**Health Precinct Stage 1 Development
The University of Sydney, Camperdown Campus (SSD 7974) - Notice of Exhibition**

Thank you for your letter dated 9 October 2017, requesting Transport for NSW (TfNSW) review and comment on the above.

SWEPT PATH ASSESSMENT
DRAWING NO. N116130-01-02

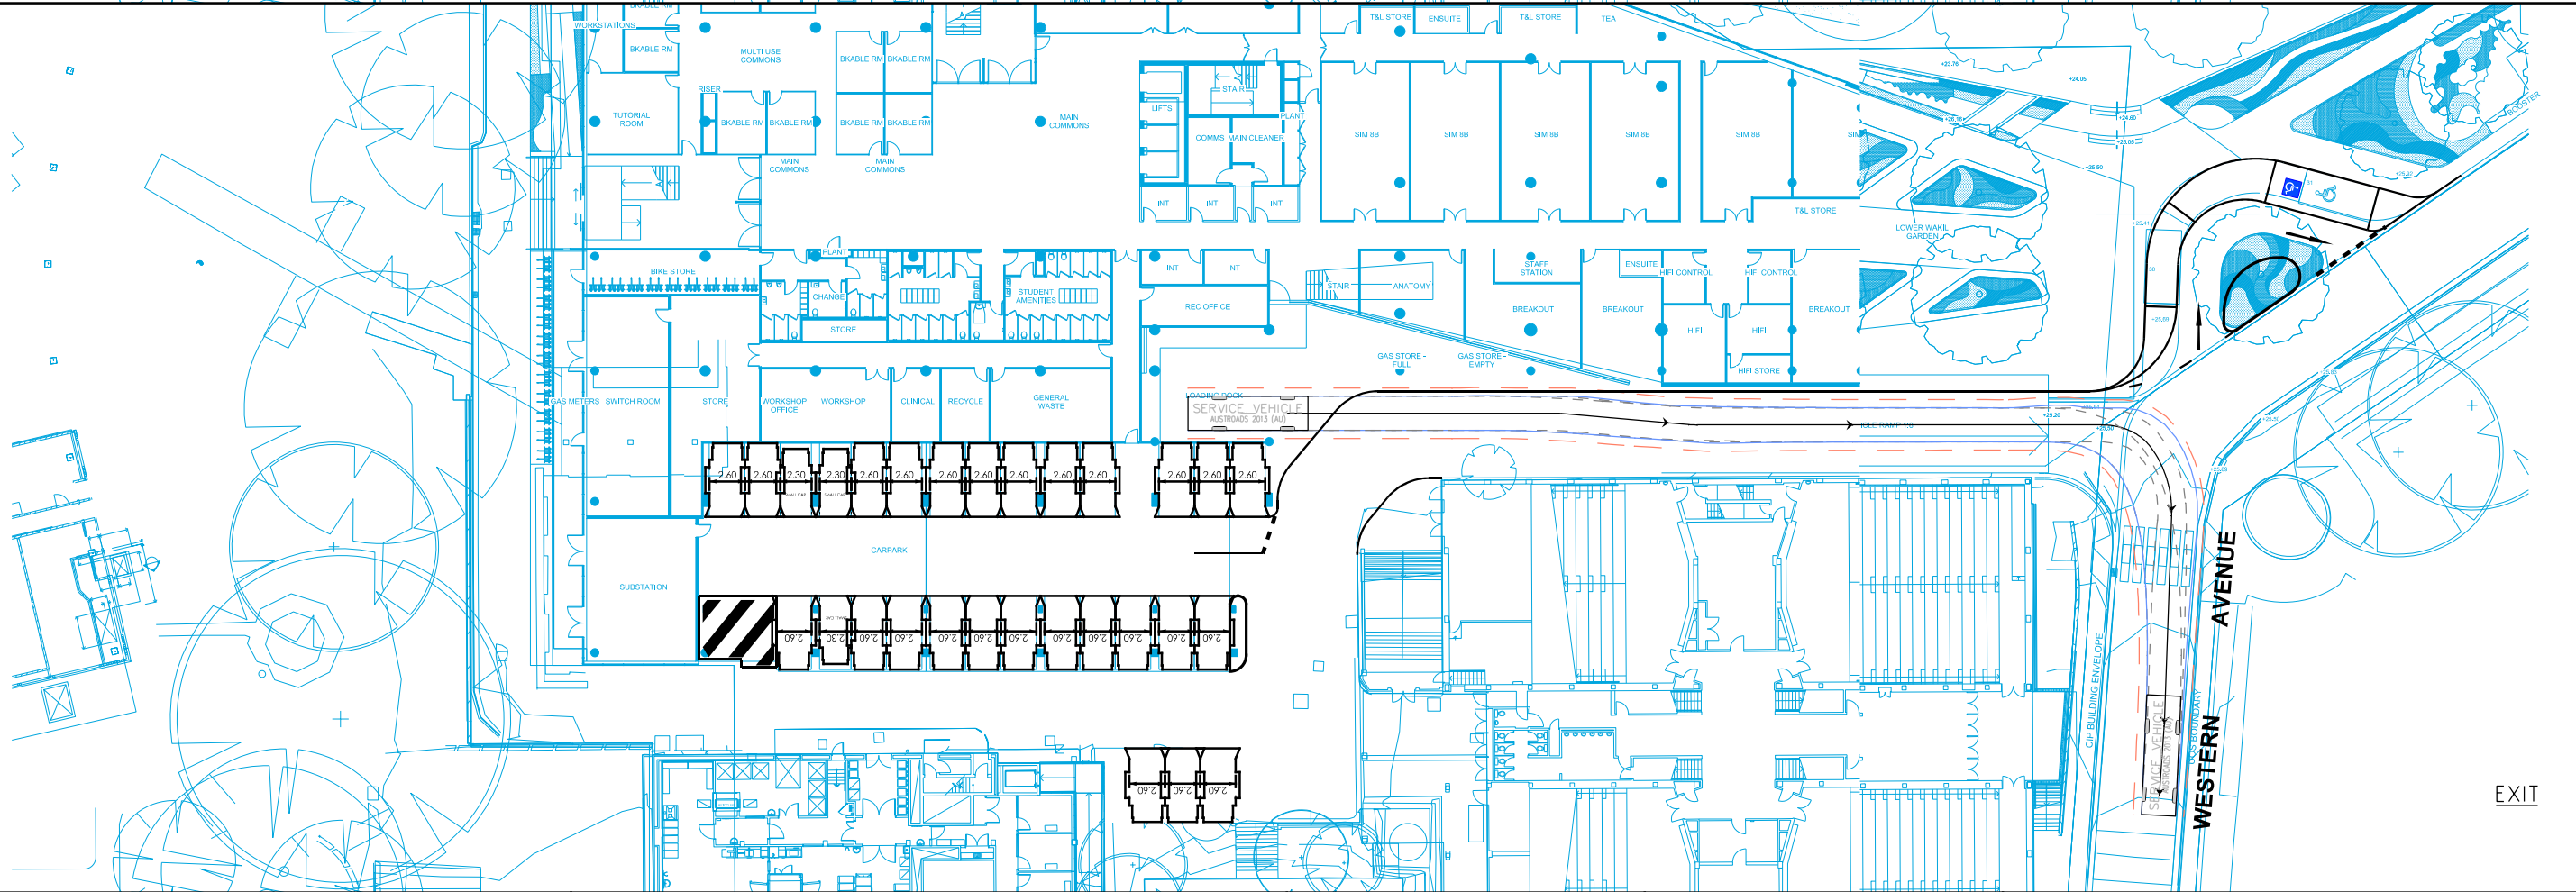
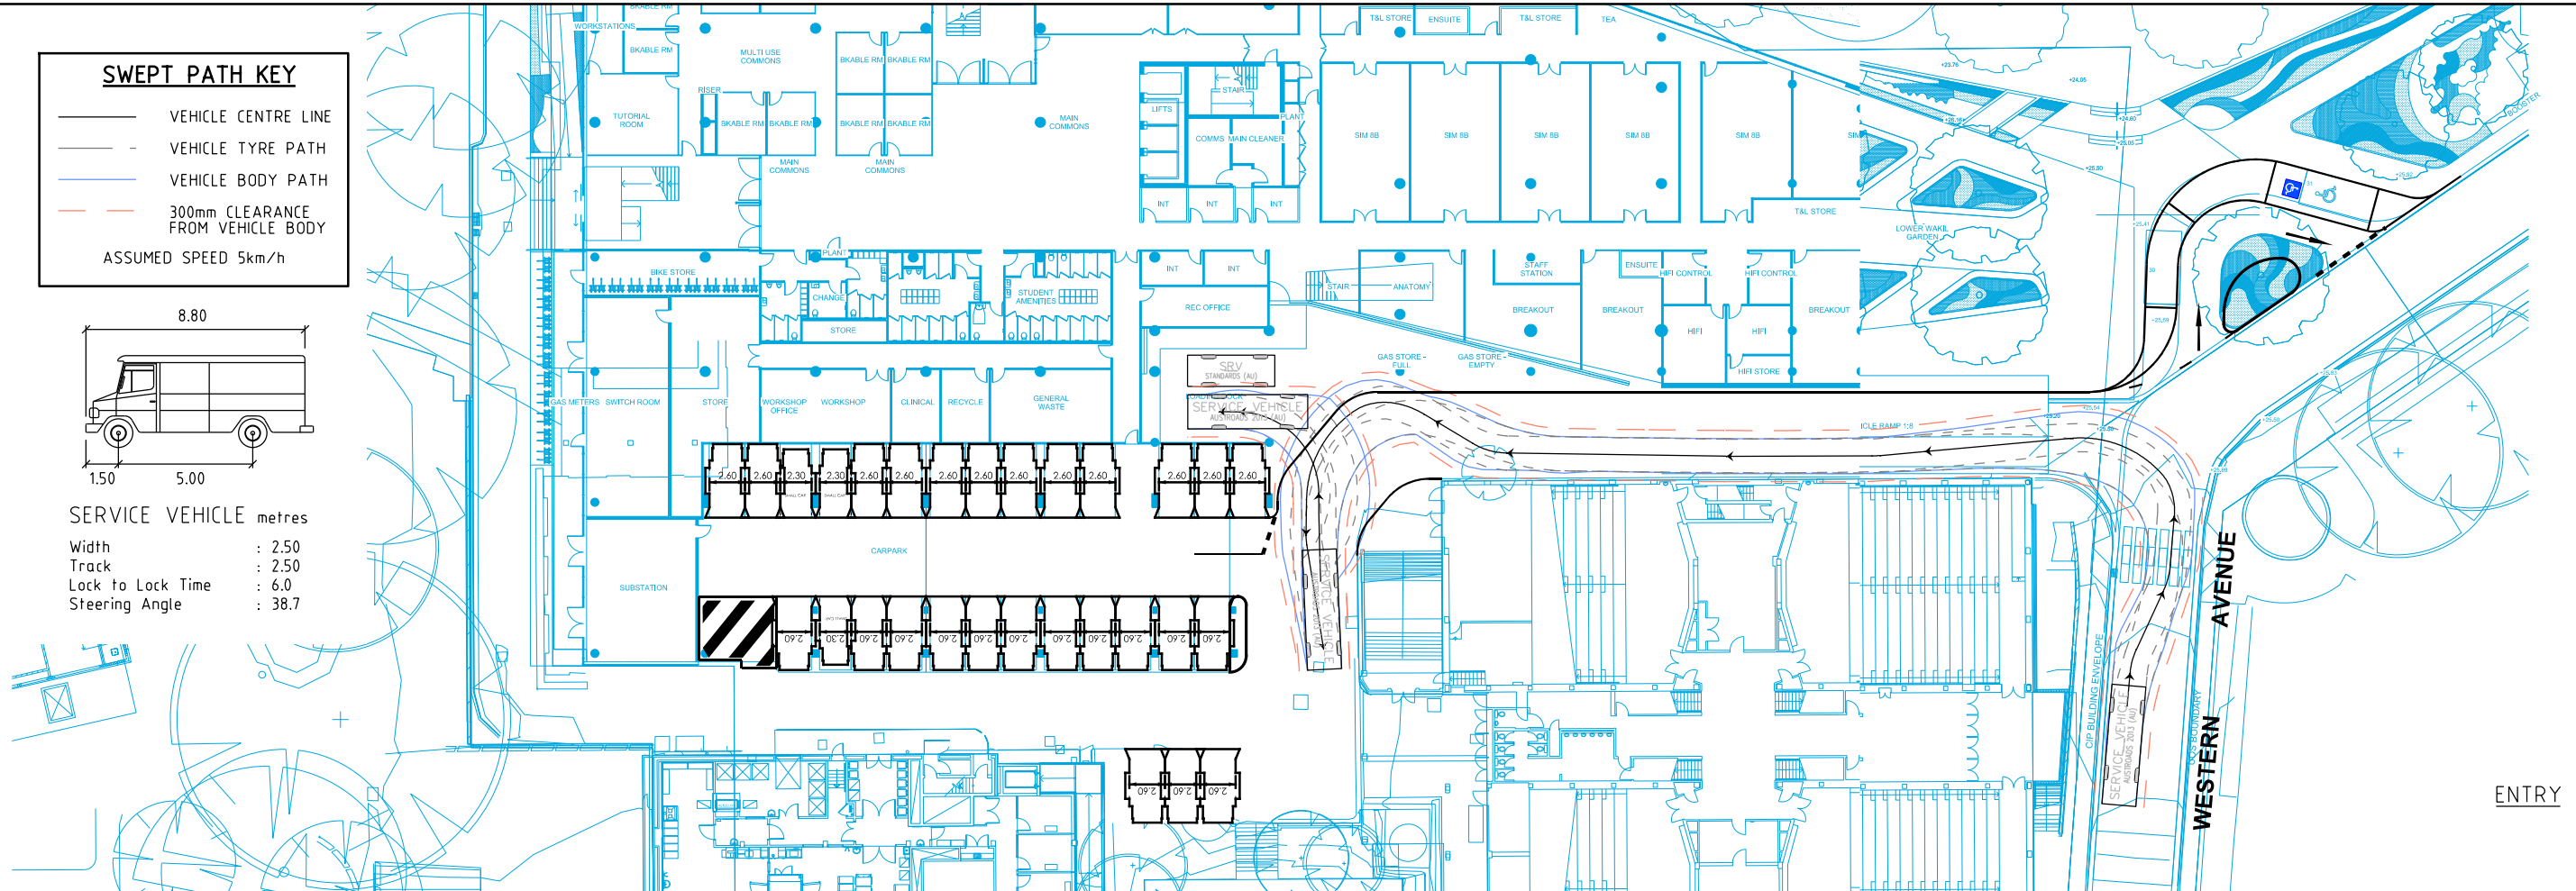
- The proposed access arrangement requires service vehicles to straddle along Western Avenue to make the turns (ingress/egress) to the site and the loading dock. This proposed access arrangement would not be able to accommodate simultaneous vehicle movements into the site for general traffic and service vehicles, which carries a safety risk for pedestrians as the location of the straddling would occur near a pedestrian crossing; and
- Sheet 6 of 7 of the swept path drawing shows swept paths for 8.8m and 12.5m vehicles using the area near the proposed drop off zone to turn around. The purpose of these vehicles is not clear, including how these movements would be achieved within the proposed kerb alignment.

A Road Safety Audit (RSA) should be undertaken by a TfNSW accredited road safety auditor. The design drawings should be reviewed based on the results of the RSA.
